CITY OF ALBUQUERQUE

**Re: Juan Tabo Hills Unit 3A Grading and Drainage Plan
Engineer's Stamp dated 8-22-12 (M22/D017)**

Based upon the information provided in your submittal received 8-28-12, the above referenced plan is approved for Preliminary Plat action by the DRB, but cannot be approved for Final Plat until the following comments are addressed:

JUAN TABO HILLS UNIT - 3A
GRADING & DRAINAGE PLAN

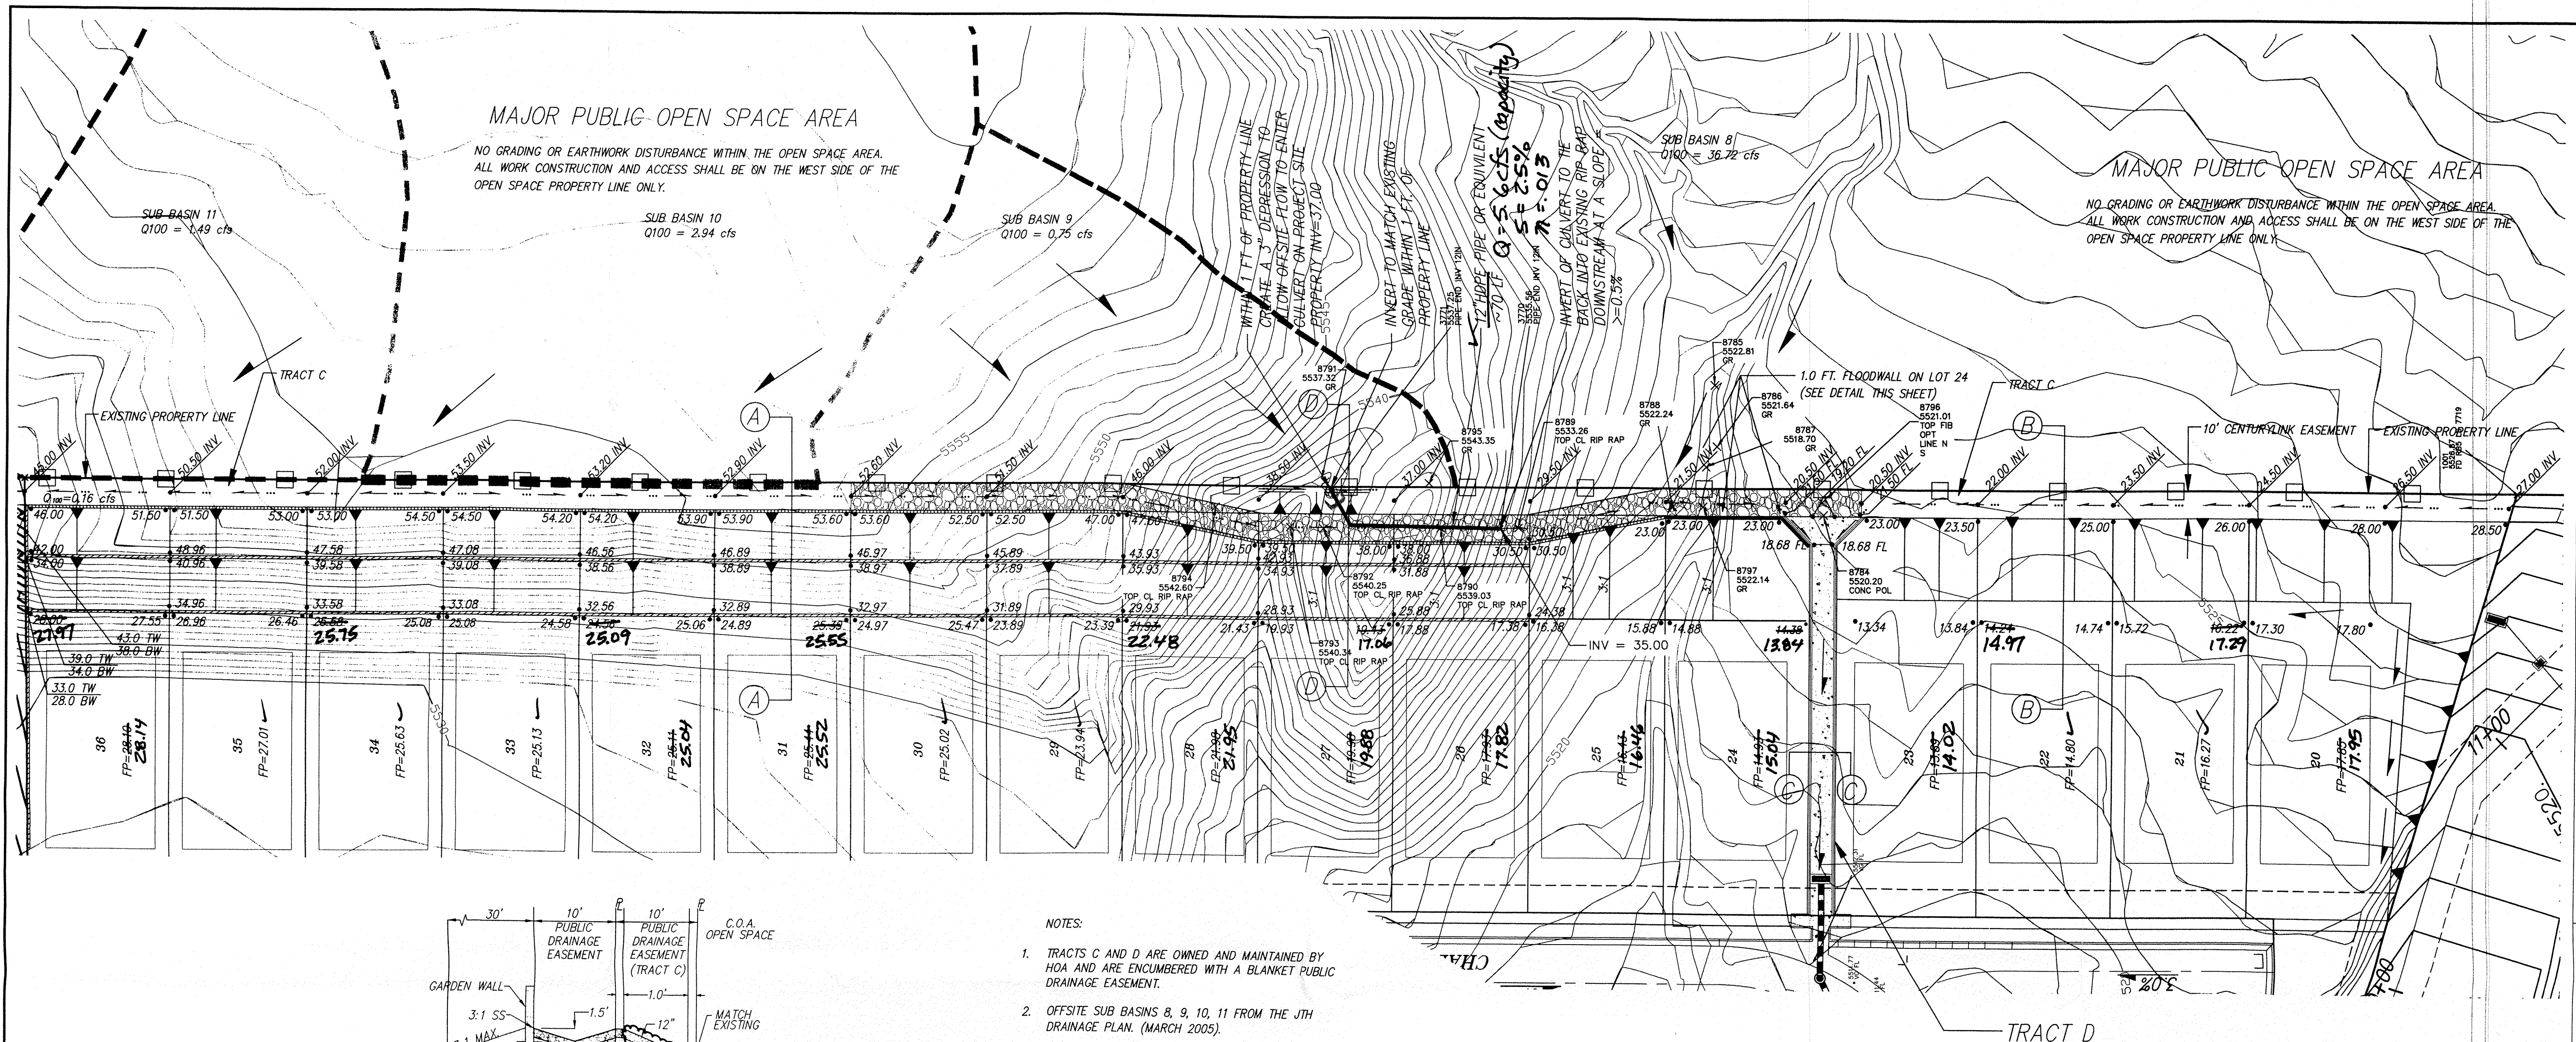
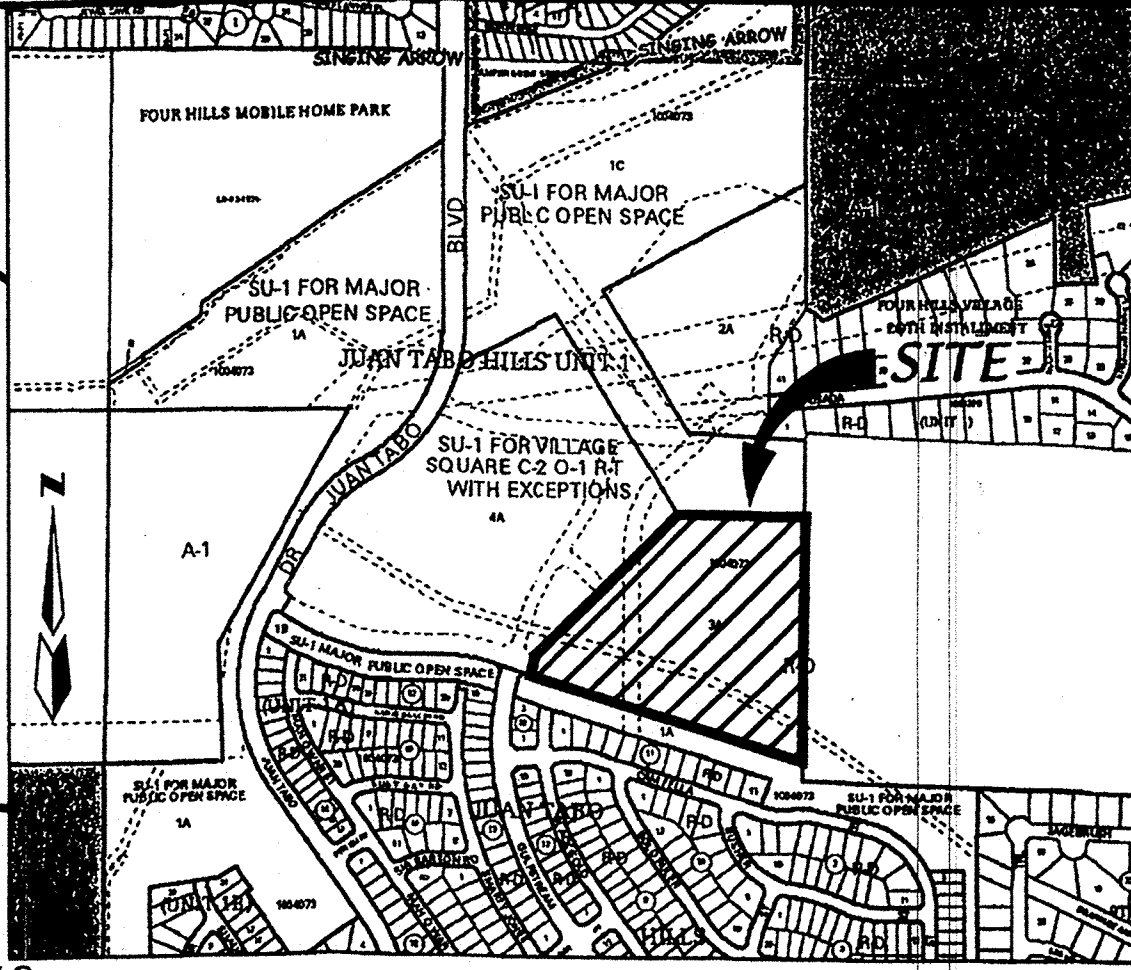
- The grading in Block 2 should be changed, because there is an approximate 6 foot grade change, without a retaining wall, between lots 2 and 6 and the rear yards of lots 2 and 3 will drain west into the corner by lots 2, 5 and 6 without an outfall.
- It appears the storm drain is mislabeled to an 18" that begins at Tract D. The Infrastructure List and the original design by Mr. Krenik has a 24" storm drain in this location.

Since this plan proposes grading on City of Albuquerque Open Space property, approval from the Open Space Division is required.
